Ribble Valley Borough Council
Council Offices
Church Walk,
Clitheroe
Lancashire
BB7 2RA

Phone: 0300 123 6780
Email: developeras@lancashire.gov.uk
Your ref: 3/2026/0555
Our ref: 3/2026/0555/HDC/KW
Date: 27 August 2026

Location: Squire House Clitheroe Road Knowle Green PR3 2YS
Proposal: Prior Notification for proposed change of use of agricultural building to Class E (dog day care) under Part 3 Class R of the GDPO.
Grid Ref: 364846 438410

TITLE: SITE PLAN

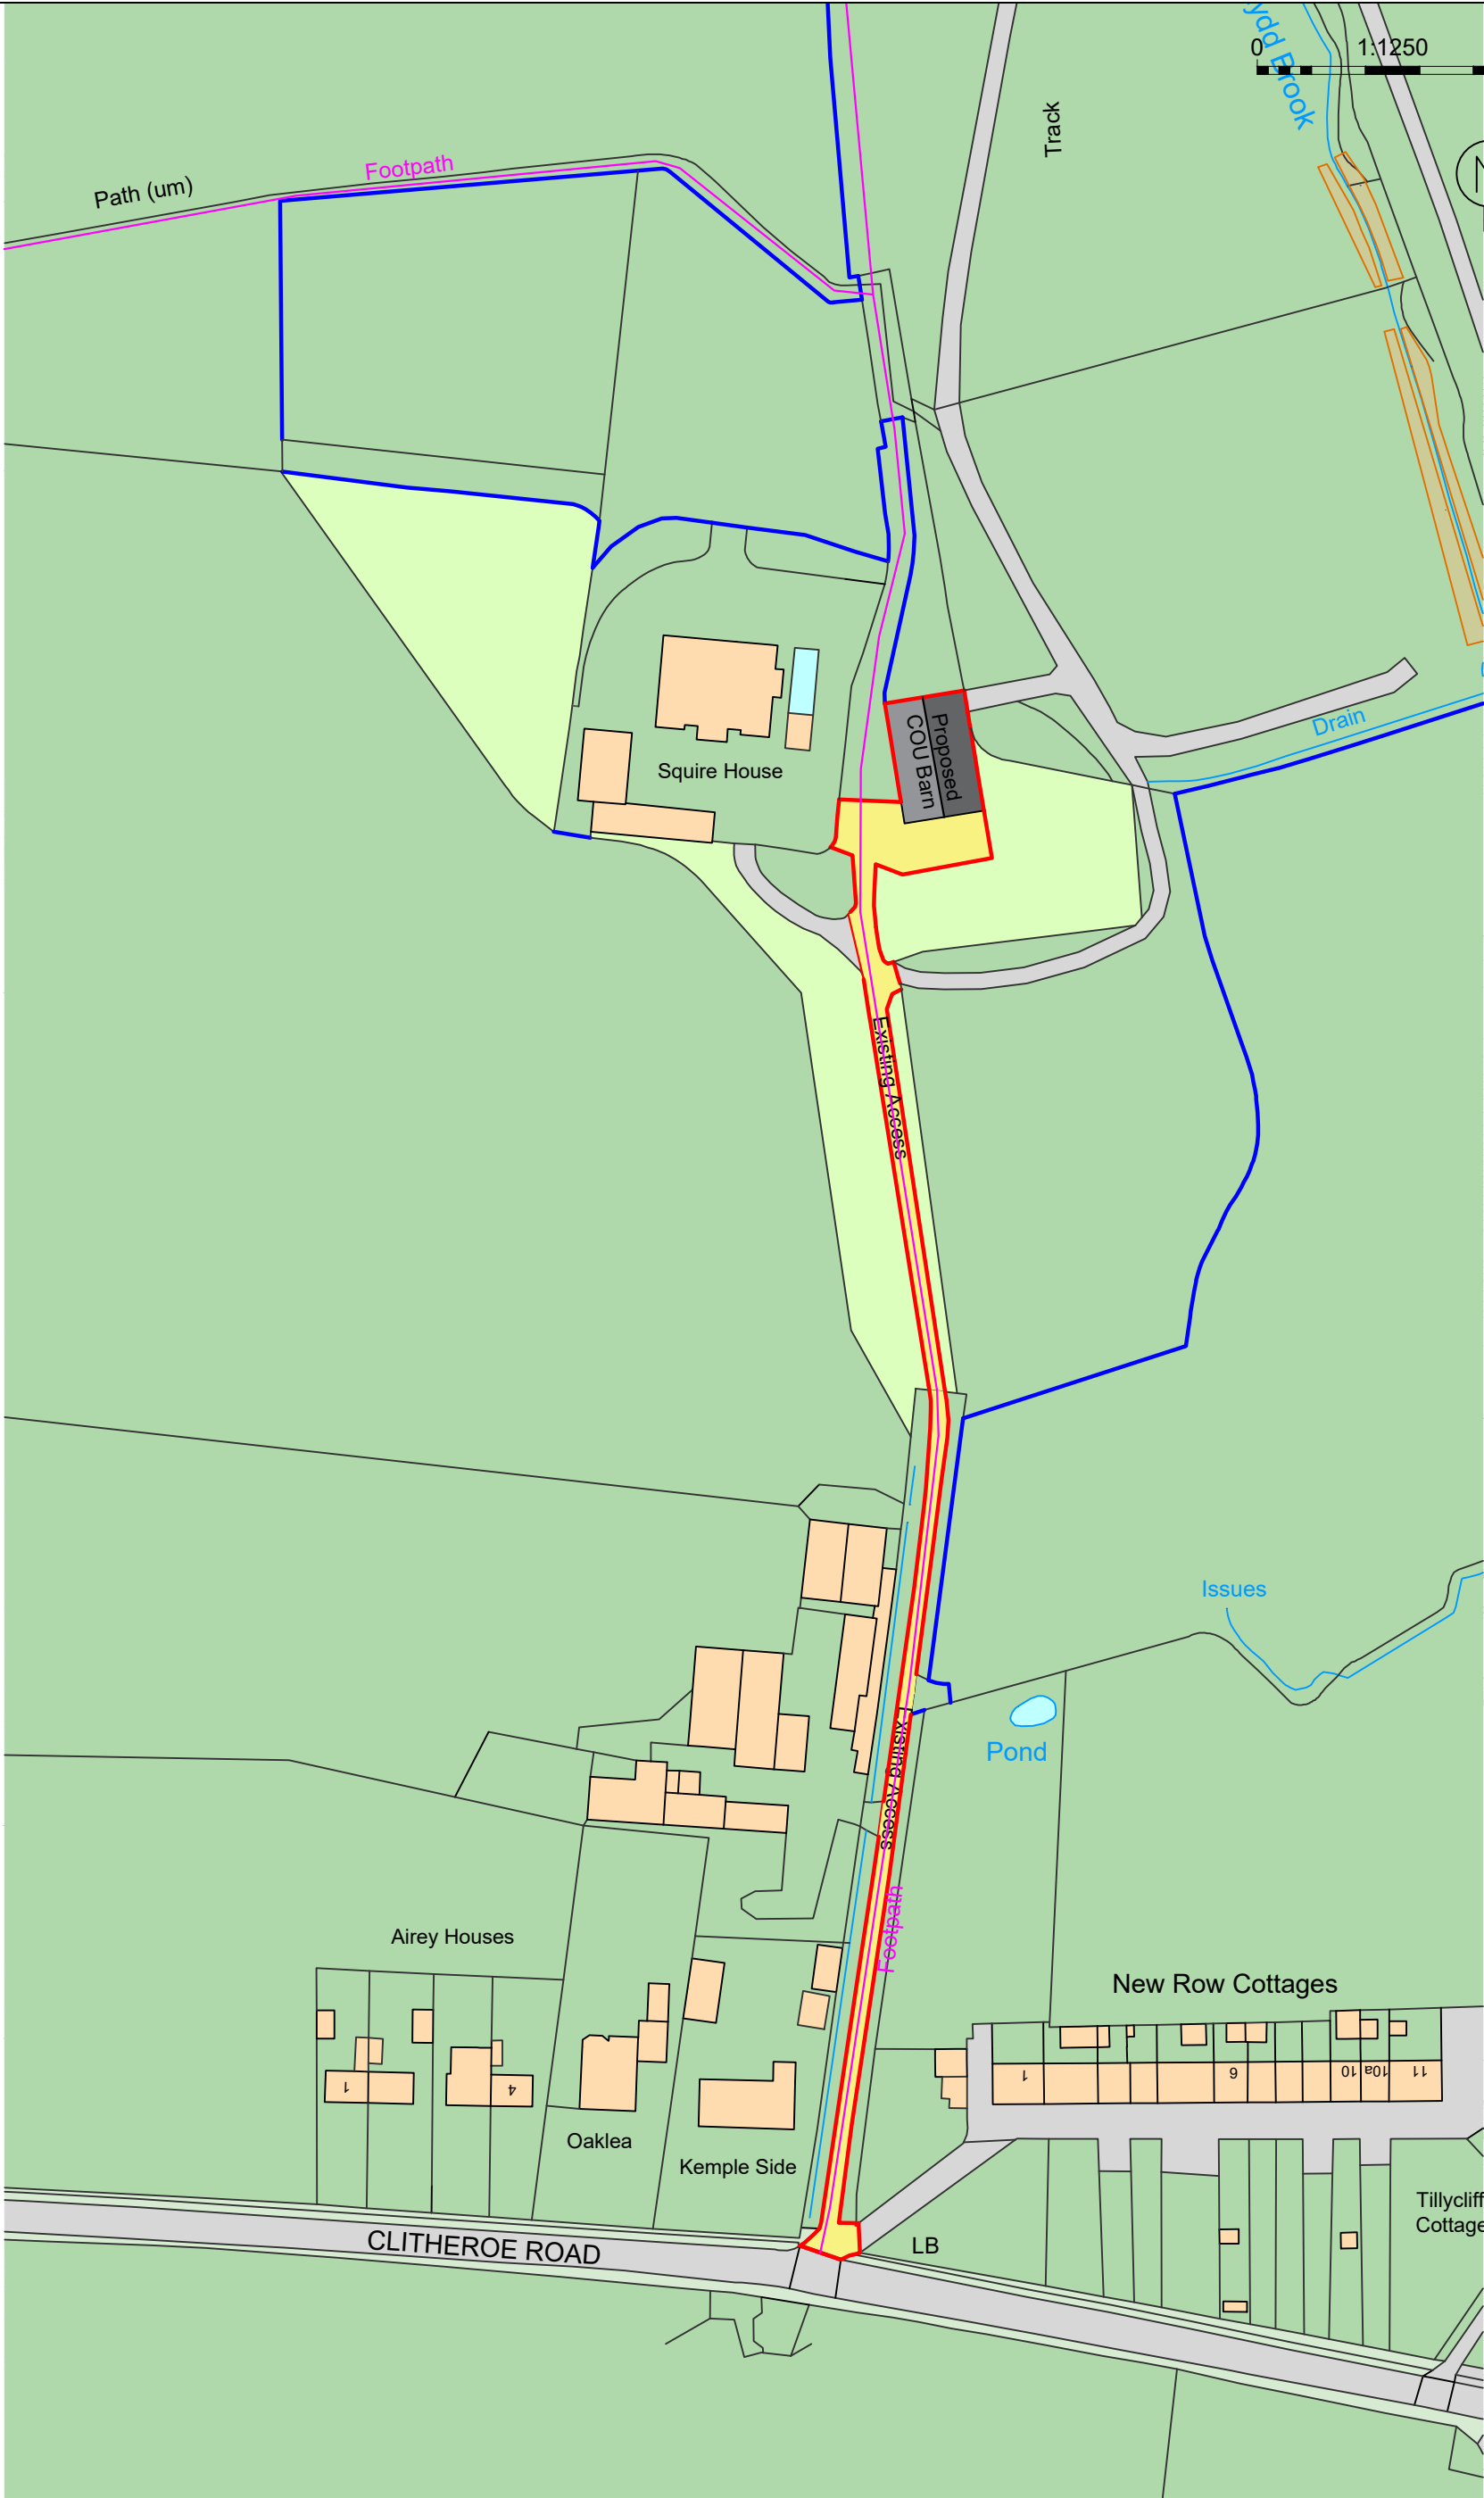
The proposal is likely to increase vehicle movements through the existing access onto Clitheroe Road and along the private access track. As such, the applicant should provide a detailed access drawing of the shared access point onto Clitheroe Road to ensure the access is appropriate to support two-way movement.

To ensure the proposal does not have a significant impact on the existing use by nearby property owners. The LHA would look for the access to be at least 5m wide for 10m behind the carriageway edge to avoid any unnecessary waiting within the carriageway and reduce conflict at the access point.

In respect of site access, the proposed development is expected to increase vehicular movements along the shared private access track and at its junction with Clitheroe Road (B6243). To demonstrate that the access arrangements can safely accommodate the additional traffic generated by the development without adversely affecting existing users of the track or the public highway, the applicant should provide a detailed scaled access drawing of the junction. This drawing should show the access can be widened to a minimum width of 5 metres for at least 10 metres behind the carriageway edge, enabling two-way vehicle movements and reducing the likelihood of vehicles waiting within the highway or causing conflict at the junction.

1 FLOOR PLAN
SCALE: 1:200 @ A3

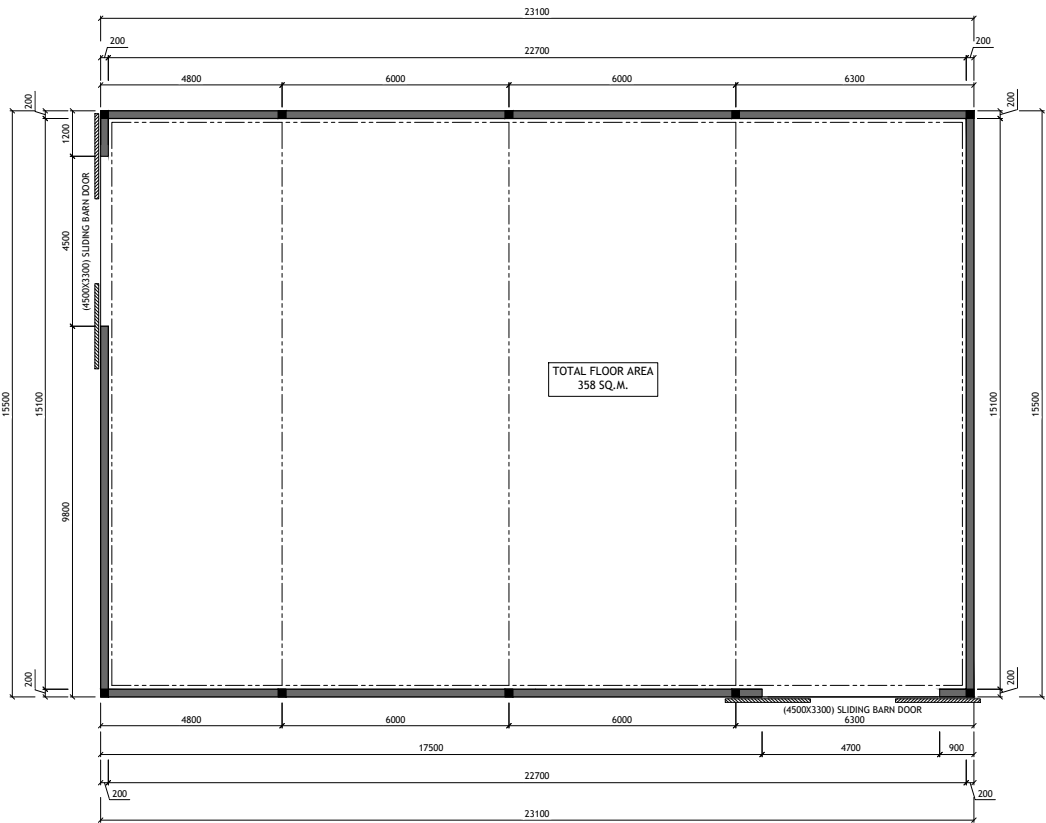
A parking plan has been submitted as part of the proposal which shows 3 parking spaces and a disabled parking space. Any proposed parking layout should provide sufficient manoeuvring space to allow vehicles to enter and leave parking bays safely and conveniently. The LHA would expect a minimum of 6 metres of clear manoeuvring depth behind standard parking spaces to enable vehicles to reverse out of bays and turn within the site. Currently there is approximately 4m of clear manoeuvring depth behind the proposed parking spaces. Adequate turning facilities should also be provided to ensure vehicles can enter and exit the site in a forward gear.

Alongside the above, an amended parking plan should be provided showing appropriate manoeuvring spaces adjacent to parking spaces within the site.
